Proposed Thames Water Utilities Ltd (Thames Tideway Tunnel) Development Consent Order

Application Reference WW010001

**Re: Proposed Thames Water Utilities Ltd (Thames Tideway Tunnel)
Development Consent Order
Land at : Albert Embankment Foreshore.**

I write in connection with the above application by Thames Water and your letter dated 19th December relating to Part 1 second written questions.

Figure 1.1 Albert Embankment Foreshore: Site context and location plan

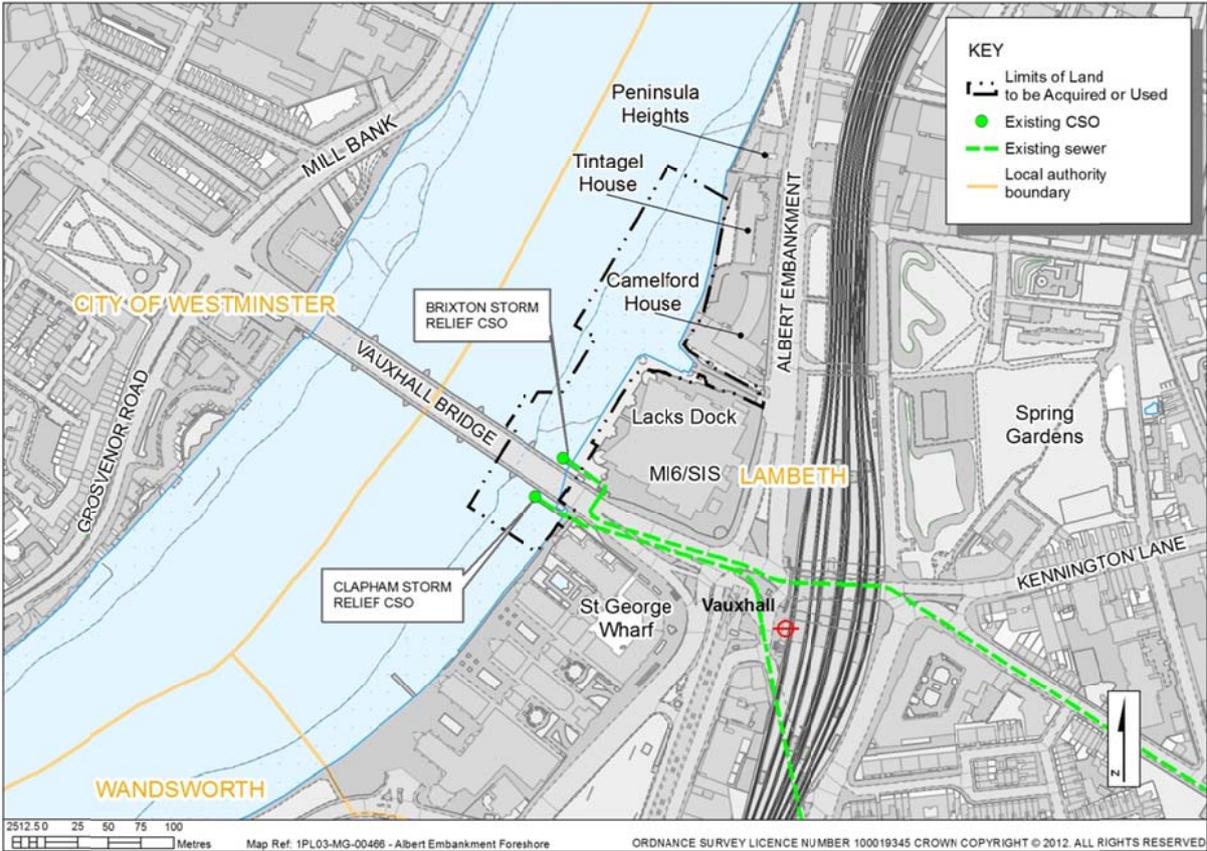
The intersection structure would appear in the foreground of the bridge on its eastern side. It would be a circular structure attached to the east embankment with graded terraces grading down into the river water.

The proposed structure would not attach to the bridge but the terraces to tier down beneath the first span on the east side of the river.

The proposal takes a very different form to the bridge and will appear as a completely different structure in the immediate foreground when they are viewed together. The proposal would not compete with the bridge because of its

relatively modest scale and its attachment to the embankment. There would be no harm to the significance of the bridge.

The Local Authority would prefer option A as the work site adjacent to Vauxhall Cross would have access and egress during low tide only and this method of construction and access would allow un-interrupted access for Duck Tours and other necessary access to the Thames via Lack's Dock. This approach is considered to eliminate concerns about the impact of construction activities on local neighbour amenity located at Peninsula Heights in terms noise and disturbance. Further this option would not involve any removal and subsequent re-instatement of the river wall or loss of any trees located between Tintagel House and Camelford House.
